**PLANNING ACT 2008
APPLICATION BY HIGHWAYS ENGLAND FOR AN ORDER GRANTING
DEVELOPMENT CONSENT FOR THE A303 SPARKFORD TO ILCHESTER
DUALLING
SUBMISSION MADE PURSUANT TO DEADLINE 8**

PLANNING INSPECTORATE REFERENCE TR010036

Action Point 18 (from 23 May Issue Specific Hearing): Applicant and SCC to set out position regarding the temporary possession and compulsory acquisition of rights and any reference to case law

INSET H: EXISTING ROADS AND PROW TO BE STOPPED UP

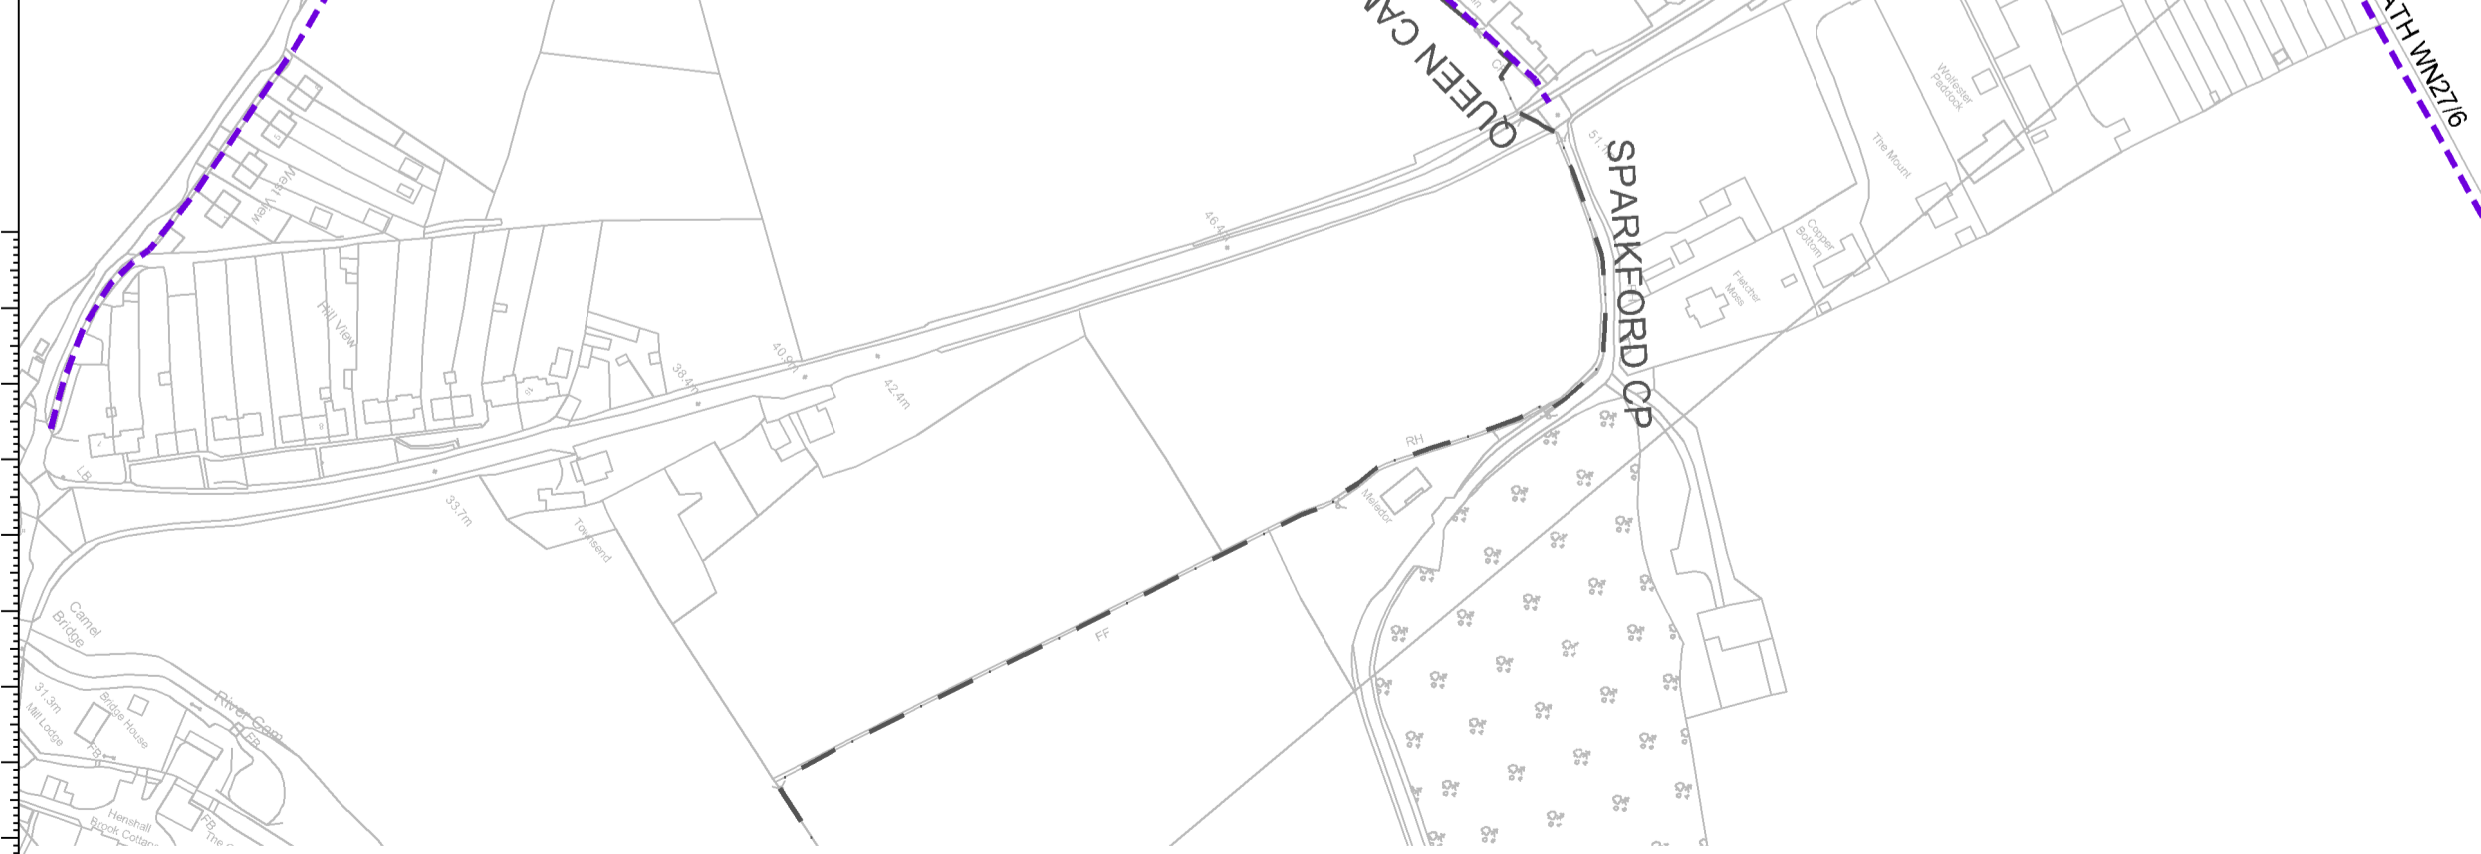
Specifically, 4/1i & 4/1j are within highway limits, but parts of the routes AB-AK and AT-AU on RoW & Access Plans fall outside of the Schedule 7 land.

In the case of AB-AK this may not be an issue as these parts fall within permanently acquired land, but there appears to be a gap on the land plans for a section of AT-AU (see extracts of plans below). This may be a minor drafting error on the RoW & Access Plans, but it does raise the question as to whether the Applicant is relying on existing title for this section to create the rights.

In relation to plot 4/1j in Schedule 7, the new bridleway (AT-AU) is within the highway limits. However, on comparing the RoW & Access Plans with the Land Plans there appears to be a gap between 4/1j and 4/7a where there is no acquisition/possession. It is not clear whether the Applicant may already own this land, and clarification is required.
